About the application

Application number: 2024/90561	
What is the application for?:	Erection of side and rear extensions with associated alterations
Address of the site or building:	82, Jenkyn Lane, Shepley, Huddersfield, HD8 8AW
Postcode:	HD8 8AW

<p>PROJECT TITLE Proposed Side and rear extension @ 82 Jenkyn Lane Shepley</p>	<p>CLIENT Ian Spedding 82 Jenkyn Lane, Shepley</p>
<p>DRAWN BY Ian Spedding</p>	<p>DRAWING NO I.S 004</p>
<p>DATE February 2024</p>	<p>SCALE Proposed Elevations 1:100 @ A3</p>

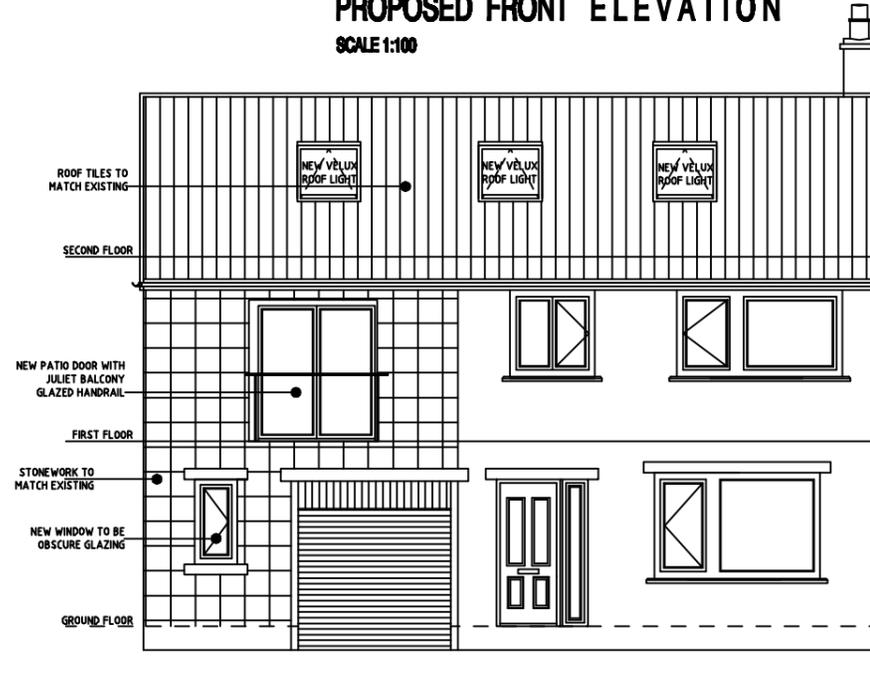
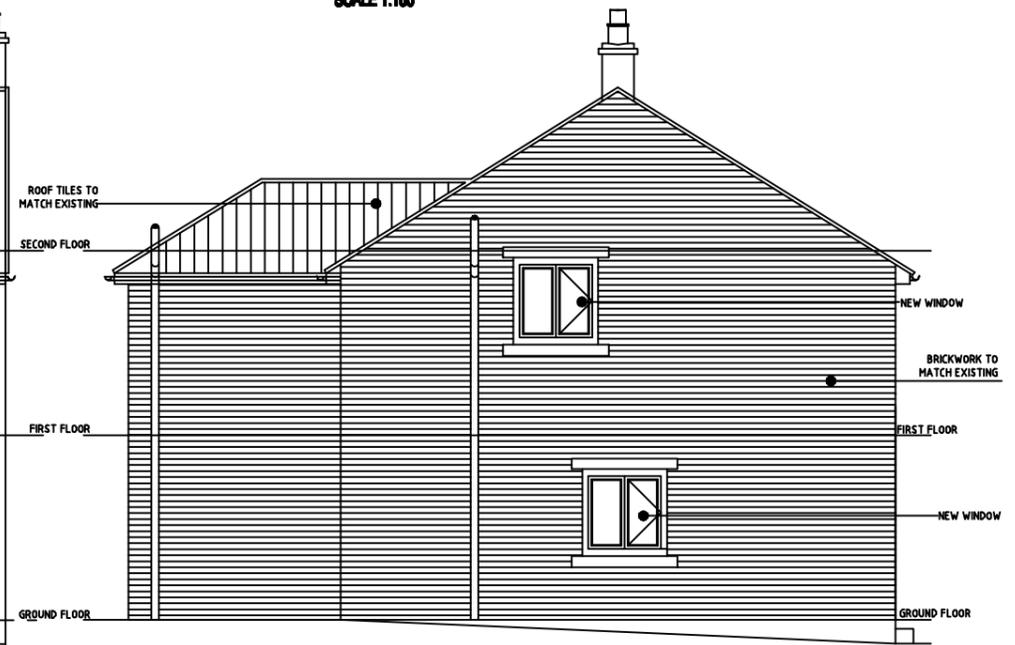
Type of comment: An objection	
Do you wish your comments to be published on the website anonymously?	Yes
I believe this proposed extension is too big and too high. The Kirklees Local Plan ((2019) states that extensions should be in keeping with the scale of the existing buildings(LP24(c) This does not appear to be the case with the proposals. The 82 Jenkyn Lane plot is higher than those on Jos Lane which back on to the property. The increase in height and scale will impact on the living conditions of these neighbouring properties, some of which will be faced with a very large brick gable wall. (contravening Kirklees House Extensions and Alterations SPD 2021) The proposed roofline appears to be the only one on the neighbouring estate (Jos Lane ;Stocks Lane Stocks Way, Jenkyn Way, and therefore is completely out of character and style with neighbourhood In addition, the property is at the end of the village and will be clearly visible on approaching the village from Stone Wood Lane. (contravening LPD24(a))
